Please ask for: Mrs D Johnson
Email: daun.johnson@arun.gov.uk
Telephone: 01903 737762
Our Ref: FG/22/22/PL
Your Ref:
Date: 16th February 2022

Application for Planning Permission

Development: Change of use of top two floors from treatment rooms to 1 No 1 bed flat and 1 No 2 bed flat. This application is in CIL Zone 4 (Zero Rated) as flats.
Location: 4 The Pantiles Ferringham Lane Ferring BN12 5NE

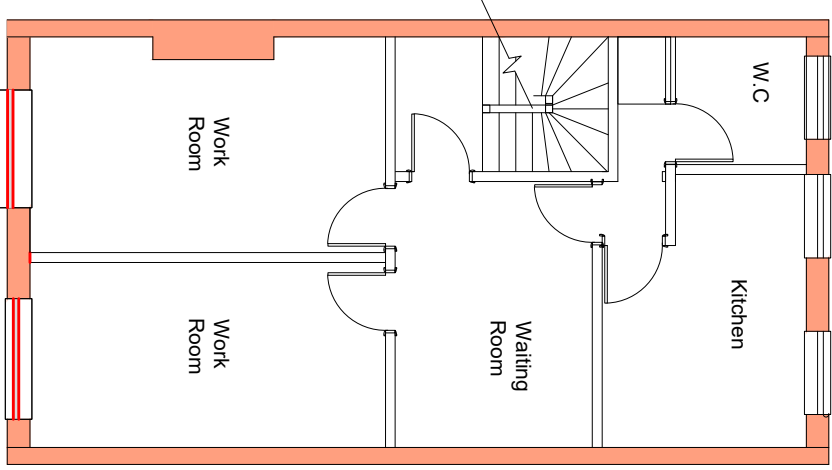
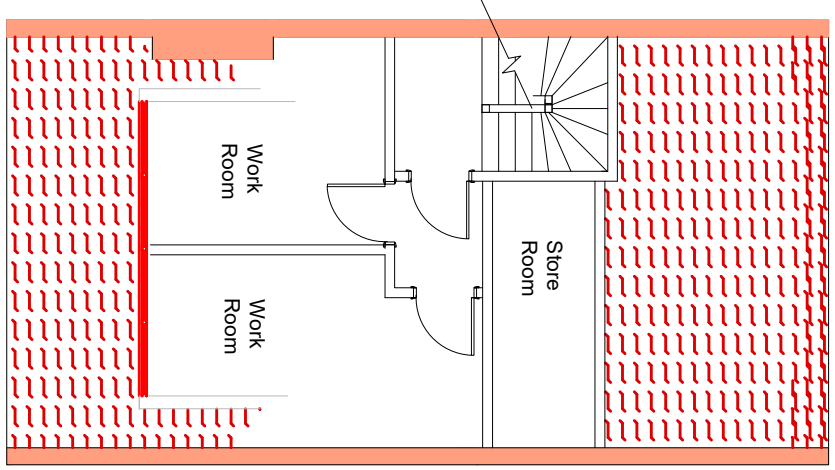
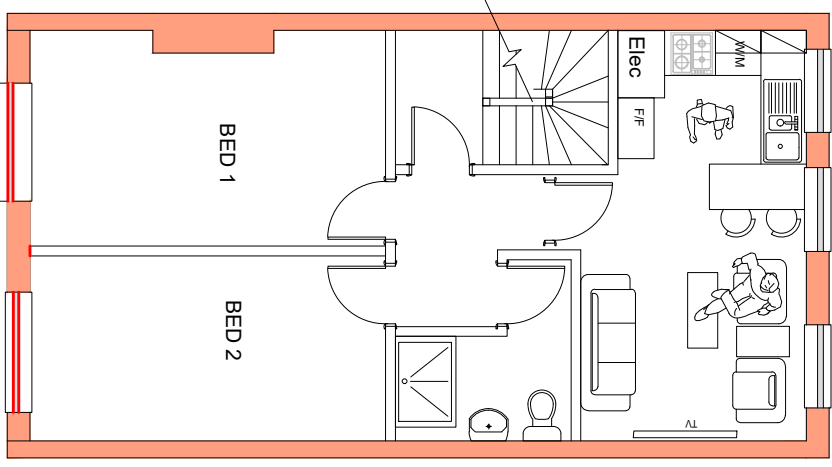
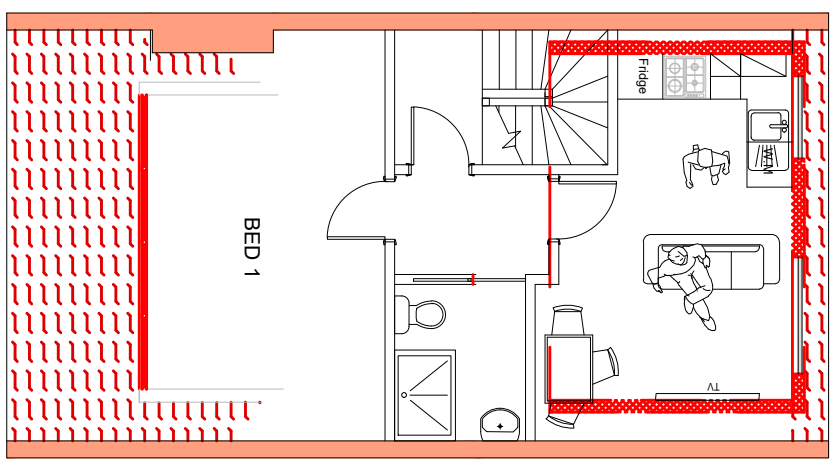
On the existing and proposed first and second floor plans (south) please clearly show the dormer windows.
